**WEST SUSSEX COUNTY COUNCIL
STRATEGIC PLANNING**

SUBJECT: EP/105/11 - Conversion of house to 2 x self contained 2 bed cottages.

46, Old Worthing Road, East Preston, West Sussex, BN16 1DY

Project: Proposed conversion from 4 bed house to 2 2bed cottages; 46 Old Worthing Road, East Preston BN16 1DY	
Drawing: Block plan	
For: Mr. Lee	
Drawn: PKS	Date: August 2011
Scales: 1:500	No: 1160/01/06
To scale when printed on A3

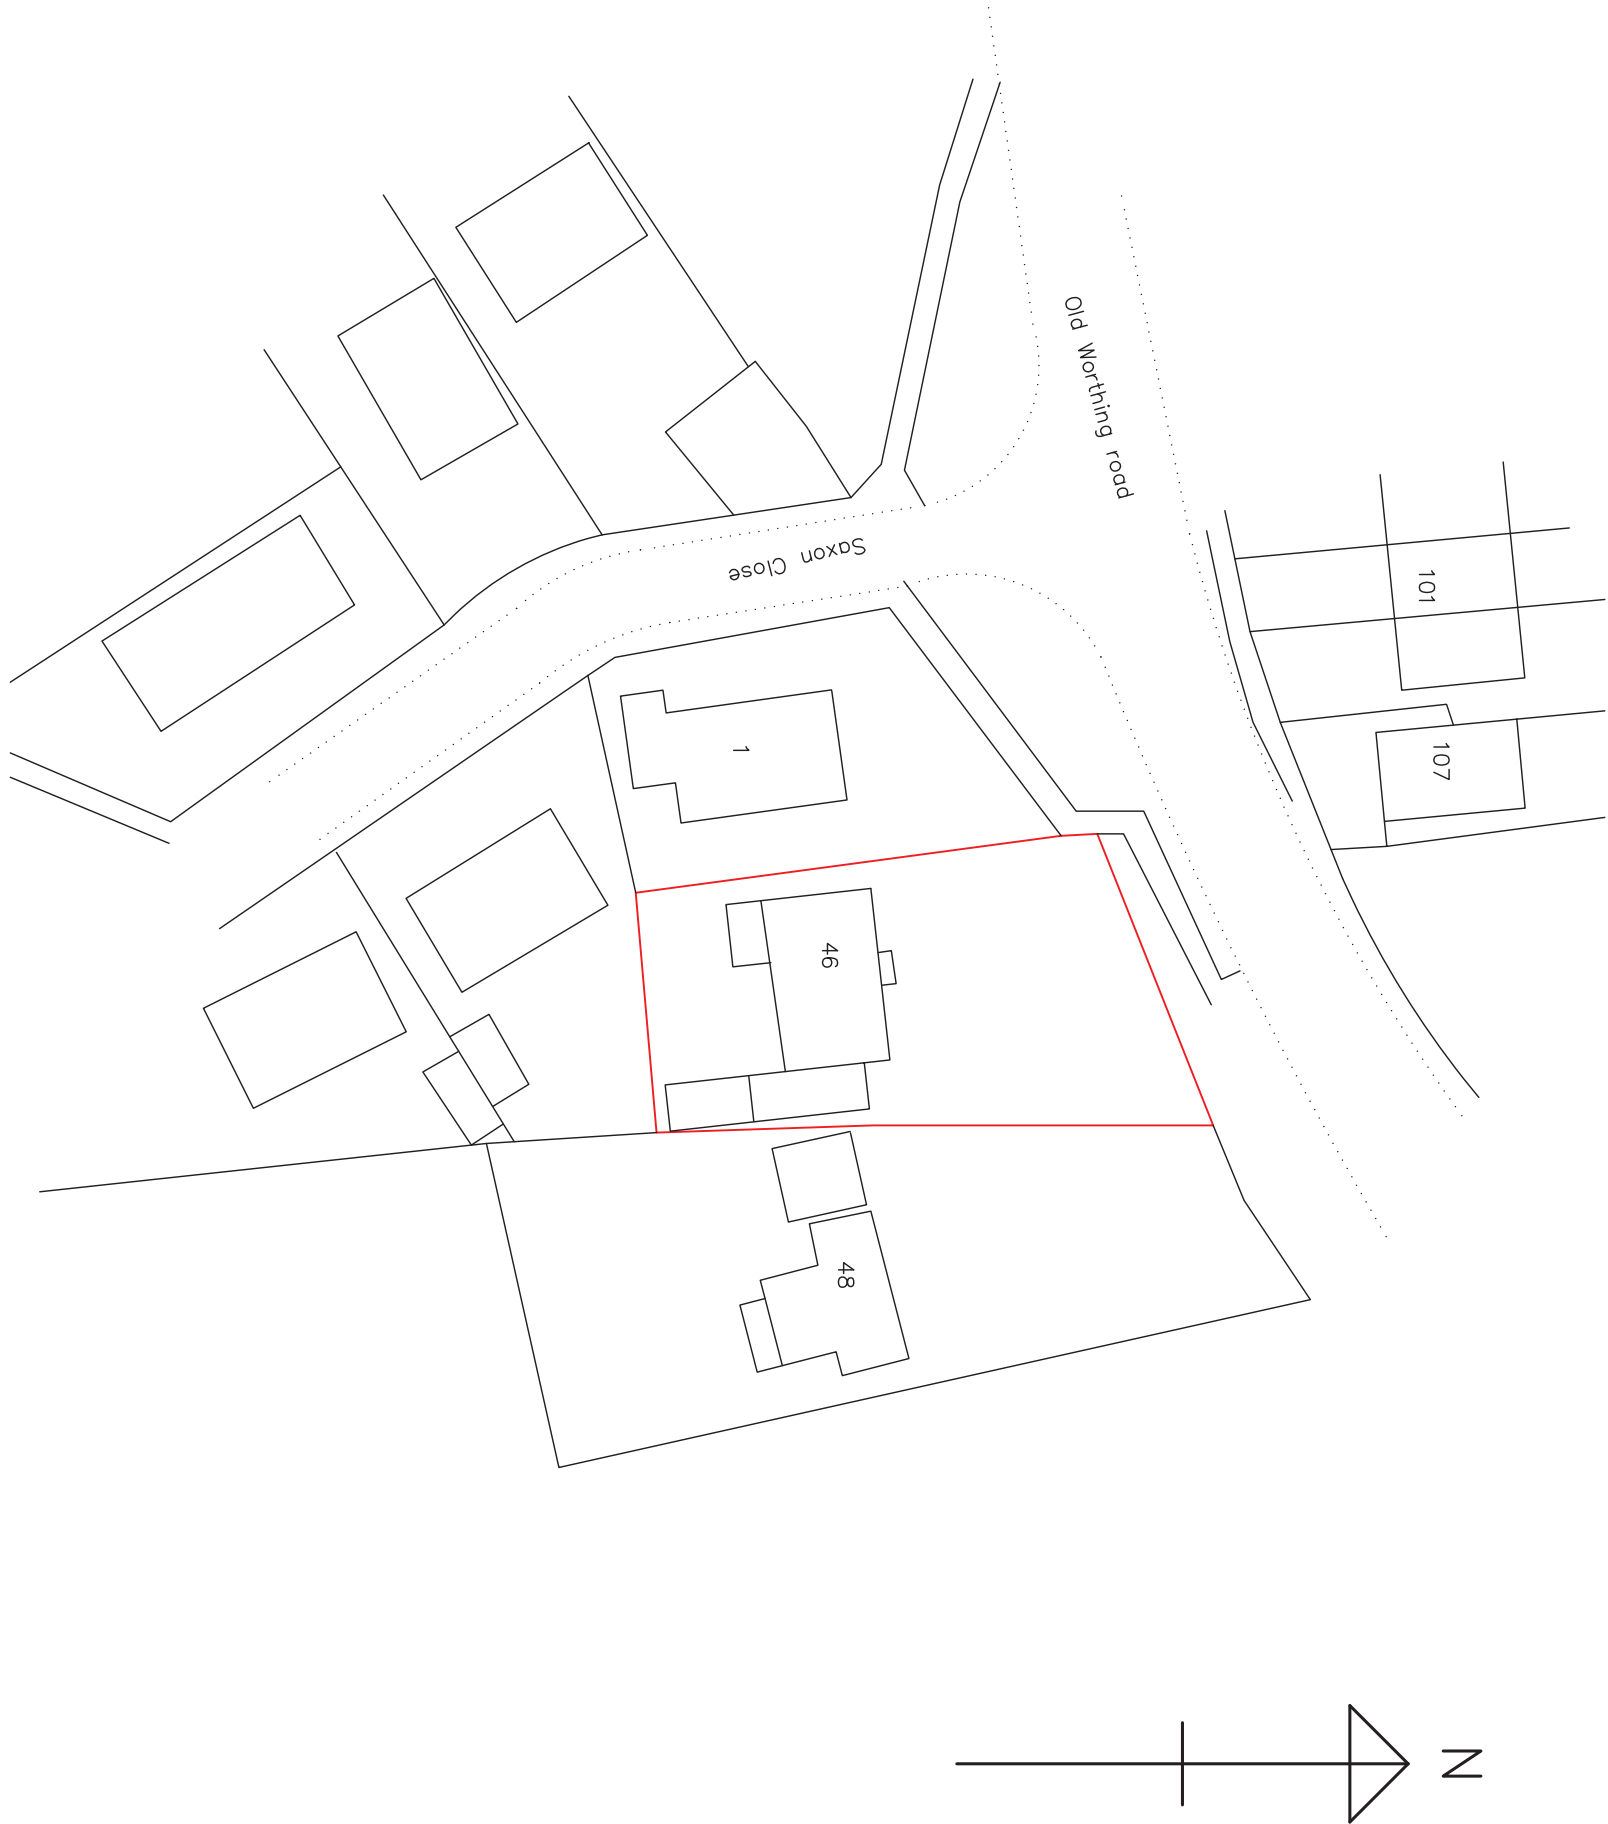
From inspection of the plans, there appears to be no apparent visibility issue at the point of access onto Old Worthing Road. I have also checked with our accident records team in relation to the 2007 motorcycle accident referred to in the East Preston Parish Council response letter. It was concluded that the accident resulted due other extenuating circumstances and not as a result of poor visibility or any of the existing accesses. In addition there have been no other accidents recorded in the vicinity of the existing access point.

If the LPA are minded to grant permission for this application a condition for vehicle parking and turning should be included.
